RE: 336 Woodward Rd SE
Grading and Drainage Plans
Engineer's Stamp Date: 12/22/2025
Hydrology File: M14D037
Case # HYDR-2026-00065

Based upon the information provided in your submittal received 2/19/2026, the Grading and Drainage Plans **are not** approved for Building Permit. The following comments need to be addressed for approval of the above referenced project:

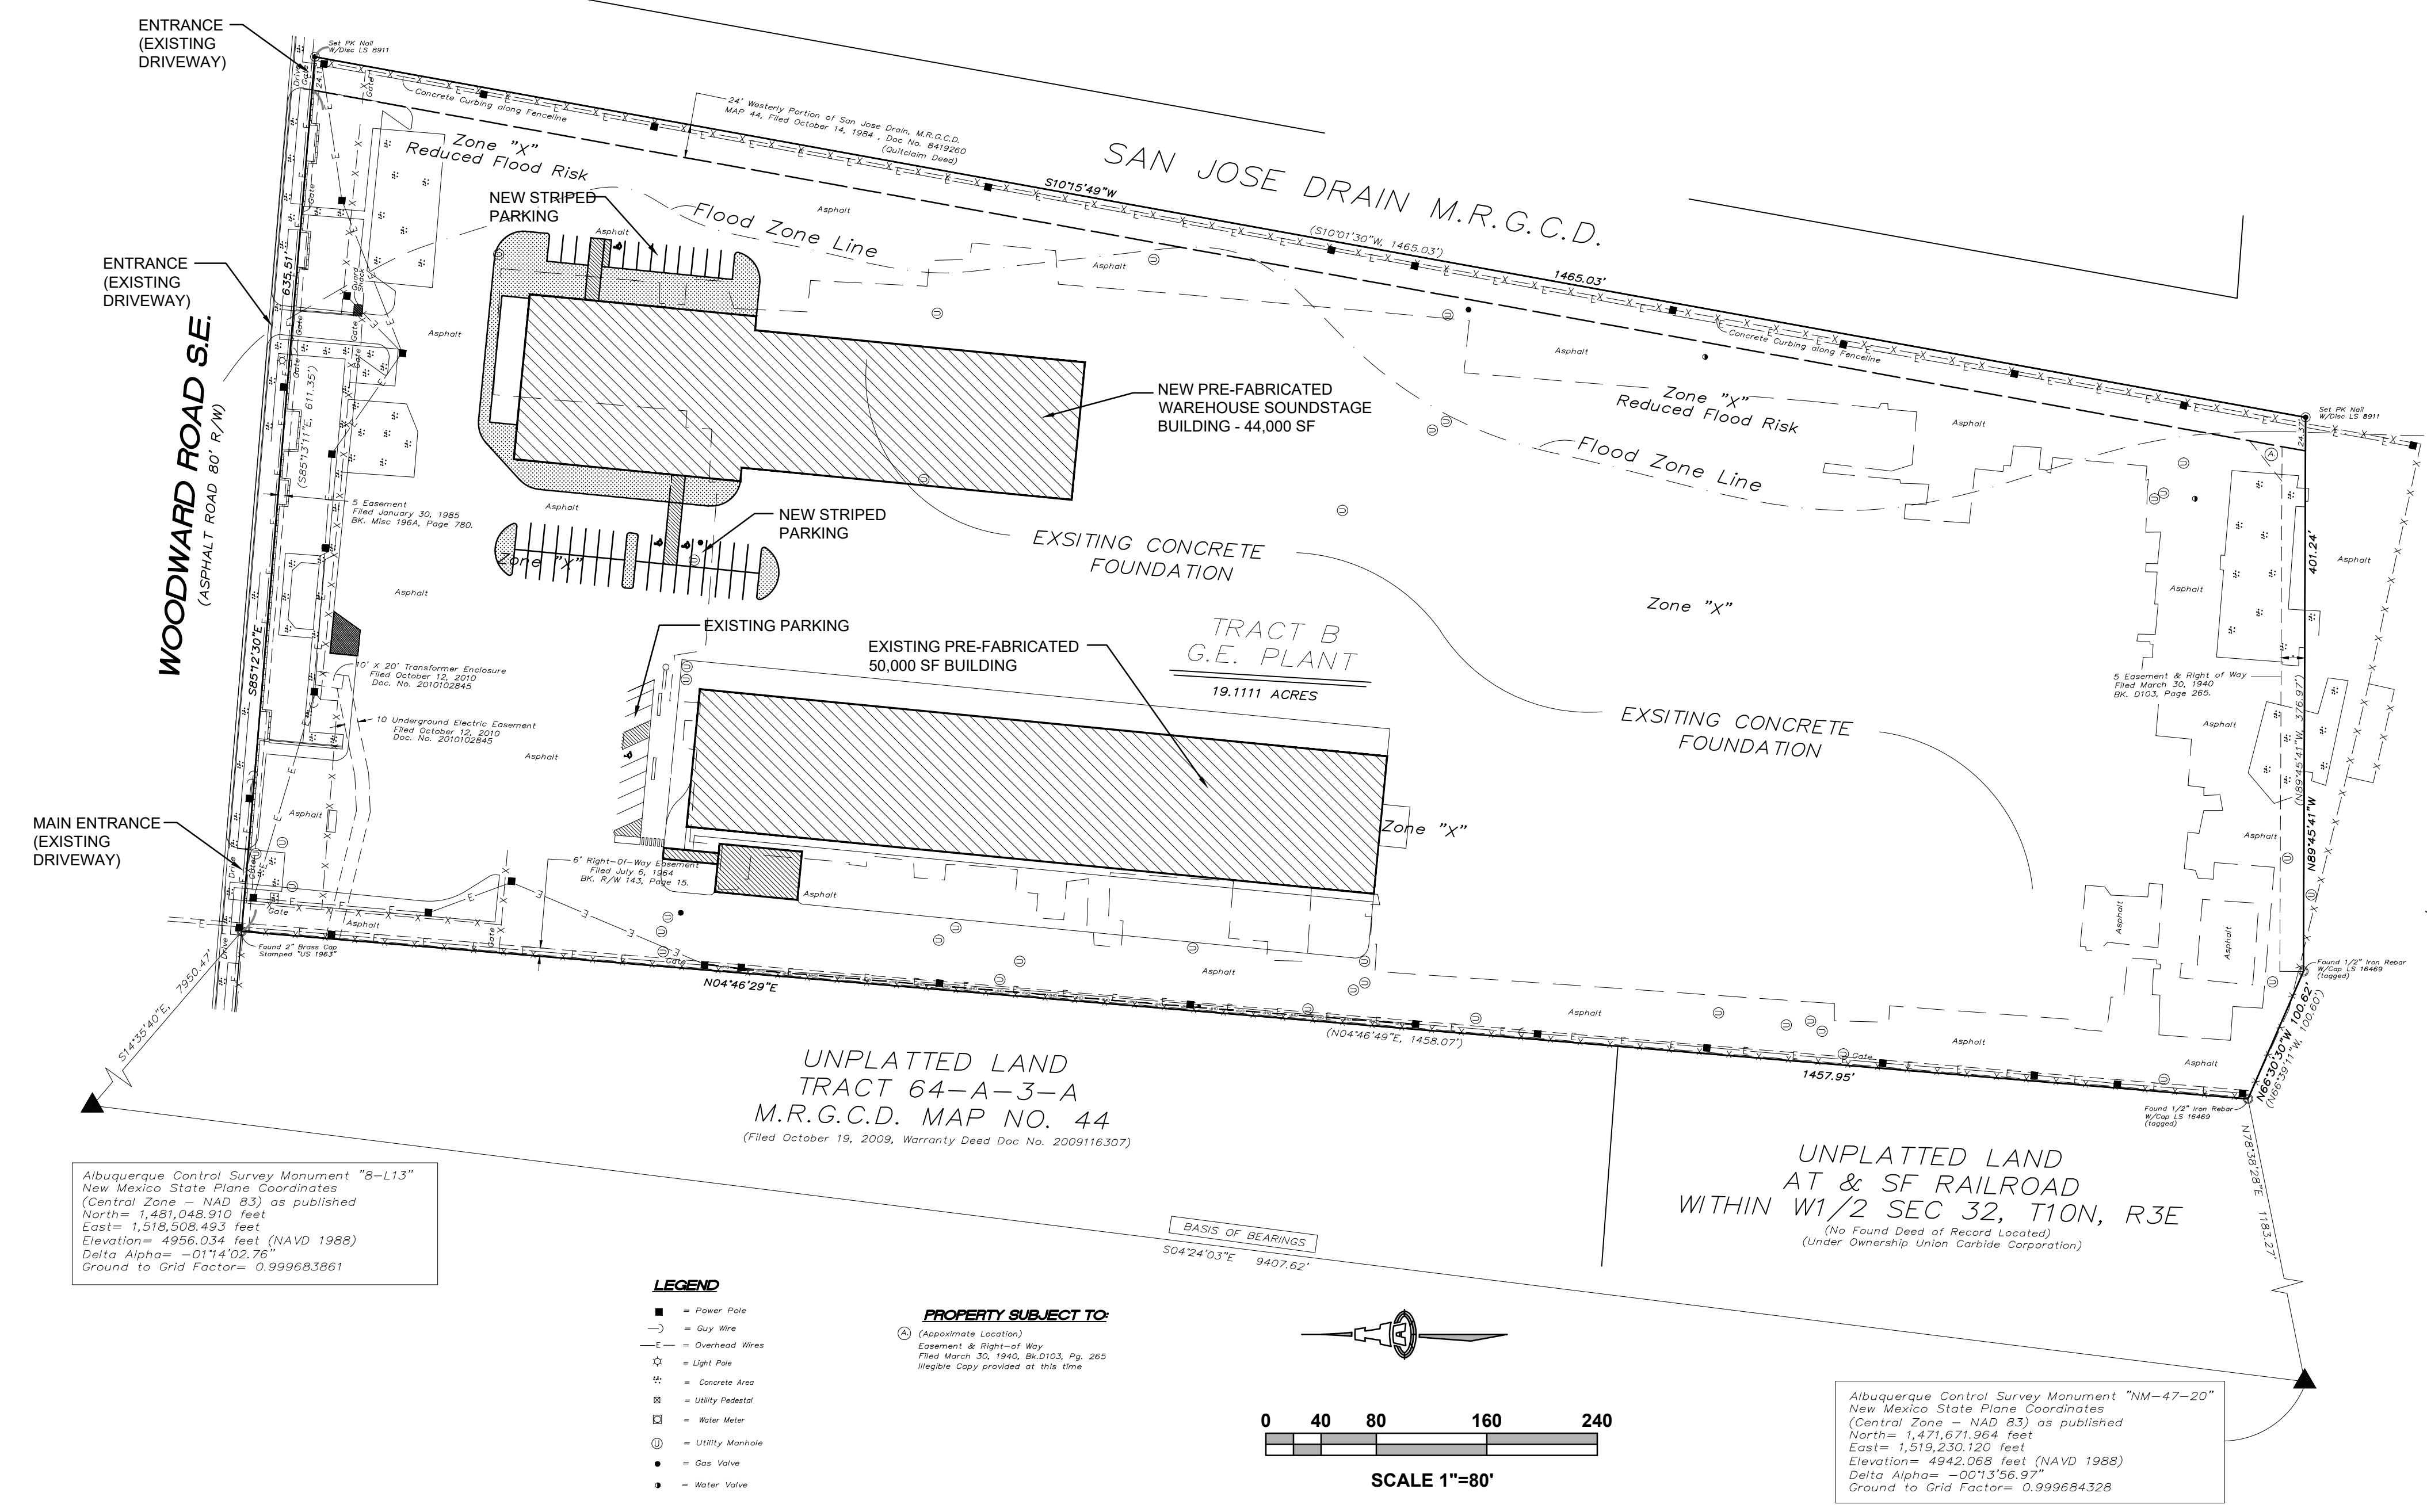
1. Provide management onsite for the Stormwater Quality Volume (SWQV) in accordance with the new drainage ordinance, § 14-5-2-6 (H). Please show the top and bottom of the ponds along with the volume for each pond. The onsite drainage should be directed to these ponds prior to being collected in a private unground drainage system. Please follow the DPM Article 6-12 Stormwater Quality and Low-Impact Development for the sizing calculations. To calculate the required SWQV, multiply the impervious area draining to the BMP by 0.42 inches for new development sites and **0.26 inches for redevelopment sites. The calculations of both the required and the provided volume of each BMP must be shown on the Grading and Drainage Plan.** Each BMP should be labeled on the Grading and Drainage Plan with the required SWQV and associated water surface elevation and the 100-year water surface elevation. Landscaping of surface BMPs is also required to be noted on the Grading and Drainage Plan

2. This site qualifies as redevelopment and is only required to retain runoff from the 80th percentile storm (Vol. = 0.26" * Imp.Area).
3. If requesting a Waiver of Management Onsite, the following conditions of the new drainage ordinance (enacted 10/2/18) must be demonstrated on the plan (§ 14-5-2-6 (H)):

Show where stormwater quality can be effectively controlled through private offsite mitigation, or through an arrangement to utilize a cooperator's existing regional

stormwater management infrastructure or facilities that are available to control stormwater quality.

And where one (or more) of the following is met:

- the lot is too small to accommodate management on site while also accommodating the full plan of development;
 - the soil is not stable;
 - the site use is inconsistent with the capture and reuse of stormwater;
 - other physical conditions exist where compliance with on-site stormwater quality control requirement leaves insufficient area;
 - public or private off-site facilities provide an opportunity to effectively accomplish the mitigation requirements of this ordinance;
 - there is an opportunity to develop a project to replenish regional ground water supplies at an offsite location; or
 - a waiver to state water law or acquisition of water rights would be required in order to implement management on site.
4. If requesting a Waiver of Management Onsite, please add a note which states, "The Owner has elected to pay the Payment in Lieu for the required Stormwater Quality Volume."
